**WELWYN HATFIELD BOROUGH COUNCIL
EXECUTIVE DIRECTOR - PLANNING, PUBLIC PROTECTION AND GOVERNANCE**

Application No: 6/2021/3353/HOUSE
Location: 49 Mulberry Mead Hatfield AL10 9EH
Proposal: Erection of a single storey front and side extension following conversion of garage into a habitable space.
Officer: Ms Kirsty Shirley

Recommendation: Refused

Ref: JEP.NOV.21B

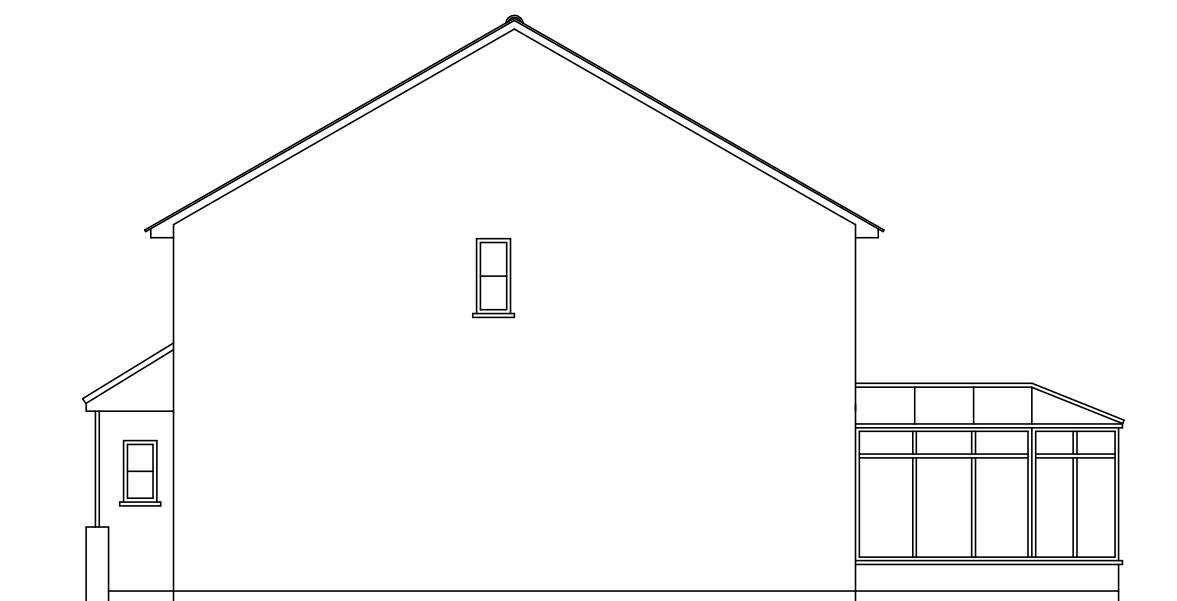
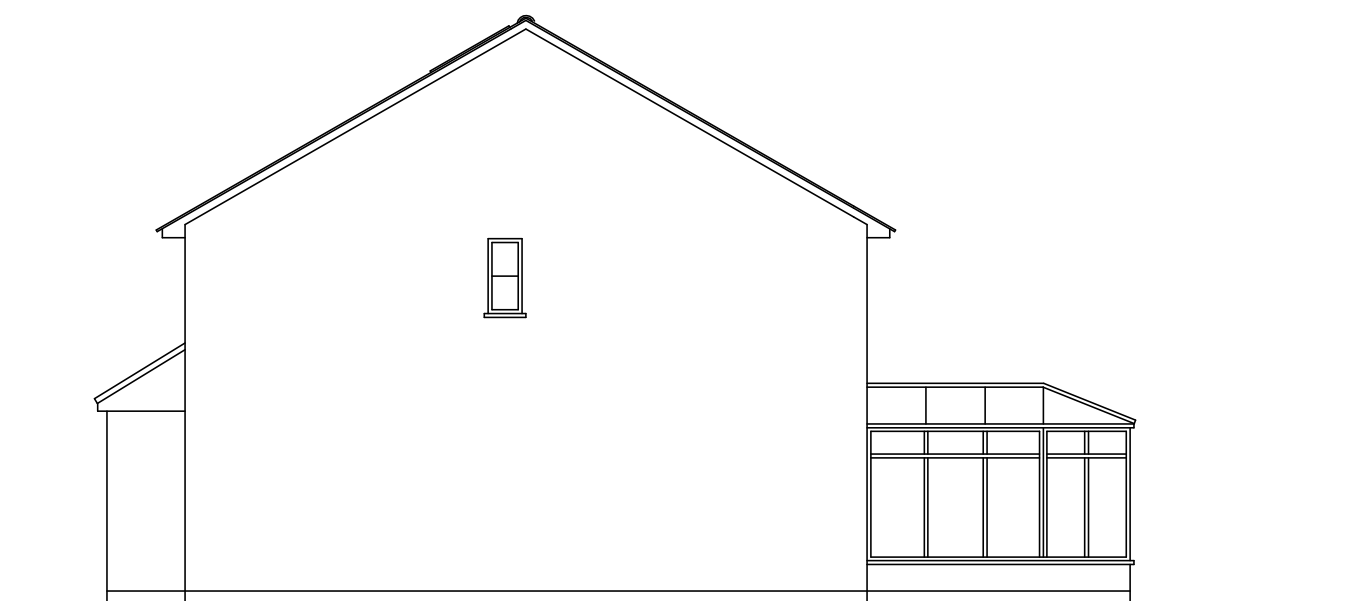
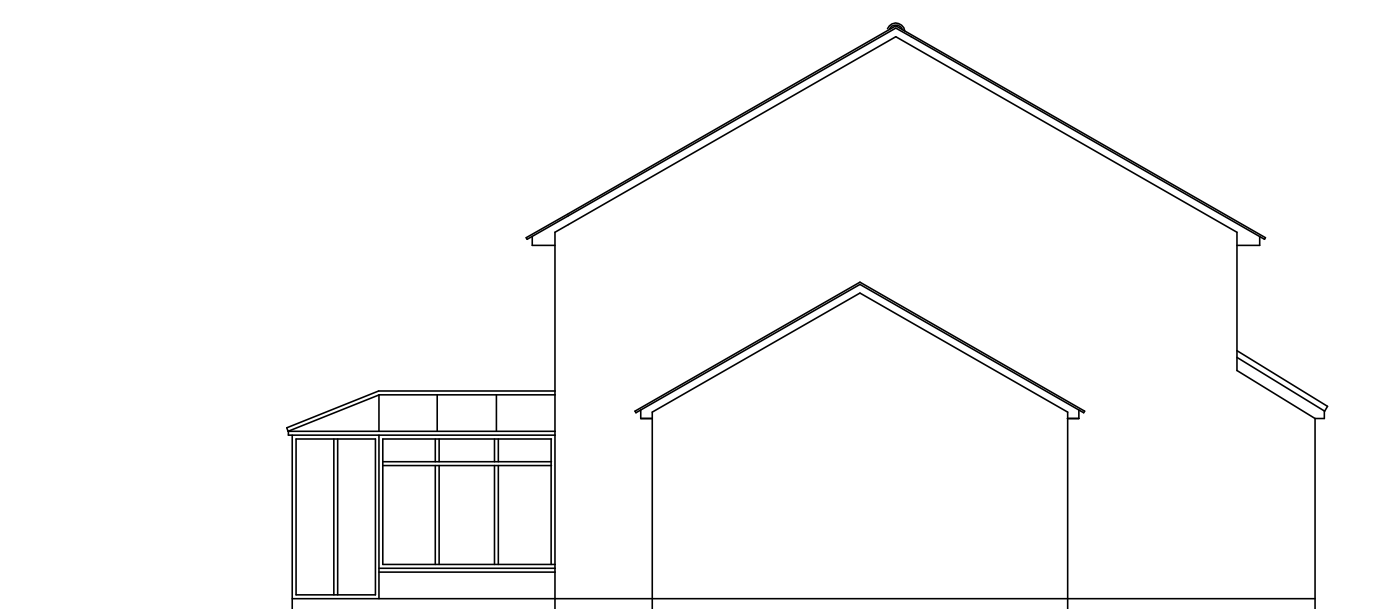
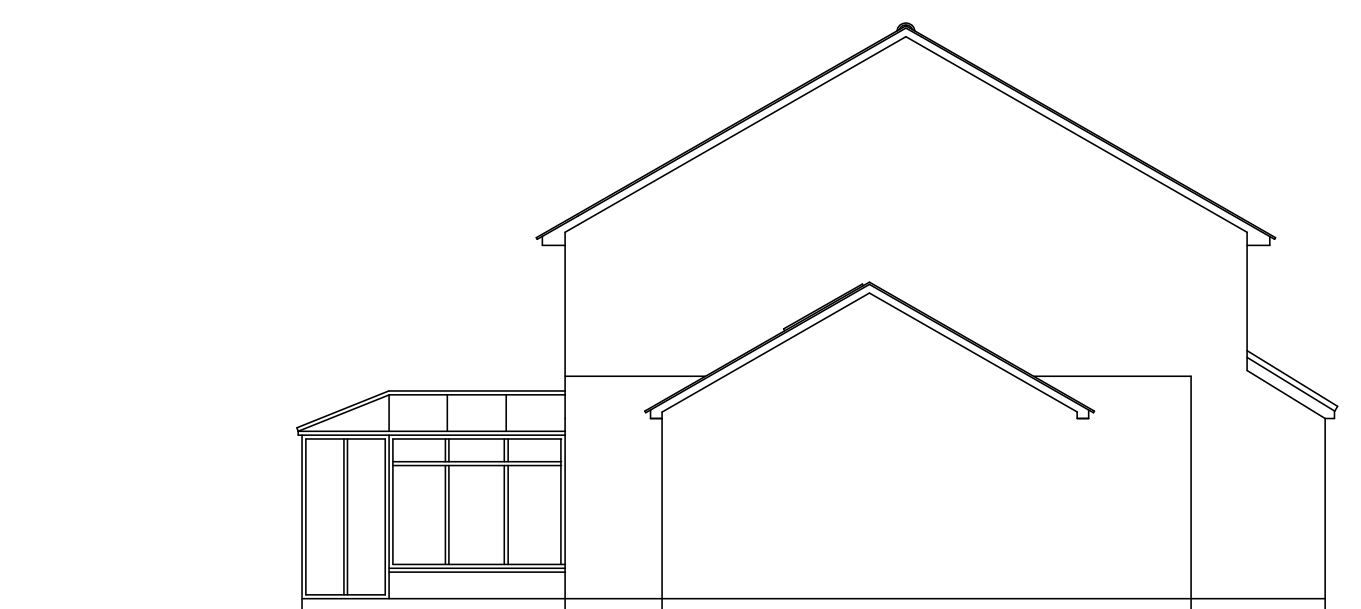
<p>dwelling or wider area by virtue of the design, positioning and scale of the development.</p> <p>The proposal also includes extending the existing garage both to the front and rear elevation. The proposed front elevation of the garage would still be set back from the front elevation of the property but the rear extension would finish in line with the existing rear elevation. The garage would then be used as a utility room and kitchen.</p> <p>The existing garage features a gabled roof in keeping with the gabled roof of the application dwelling. The proposal would maintain the existing garage roof, with a flat roof projecting from the front and rear of the current garage roof to serve the proposed extensions from the garage. The proposed flat roof would appear incongruous and out of keeping with the pitched roofs featured on both the application dwelling and predominantly seen in the wider area. While the flat roof serving the rear extension would be mostly concealed from view due to its positioning, the flat roof serving the front extension would be clearly visible from the street scene and the discordance in roof forms would detract from the character of the dwelling.</p> <p>Accordingly, the proposal would represent a poor quality of design and would fail to overcome previous refusal reason 2 of previous application 6/2021/1405/FULL.</p>

The proposed development, particularly the proposed garage extensions, in regards to its design, would fail to respect and relate to the character of the application dwelling and wider area. Accordingly, the proposed development represents a poor standard of design and is therefore contrary to Policies D1 and D2 of the Welwyn Hatfield District Plan 2005; the Welwyn Hatfield Supplementary Design Guidance 2005; and the National Planning Policy Framework 2021.

1. The proposed development, particularly the proposed garage extensions, in regards to its design, would fail to respect and relate to the character of the application dwelling and wider area. Accordingly, the proposed development represents a poor standard of design and is therefore contrary to Policies D1 and D2 of the Welwyn Hatfield District Plan 2005; the Welwyn Hatfield Supplementary Design Guidance 2005; and the National Planning Policy Framework 2021.
2. The proposal fails to provide adequate on-site parking to accommodate the proposed development. Accordingly, the proposal fails to comply with Policies D1, D2 and M14 of the Welwyn Hatfield District Plan 2005; the Supplementary Design Guidance 2005; the Supplementary Planning Guidance on Parking Standards 2004; and the National Planning Policy Framework.
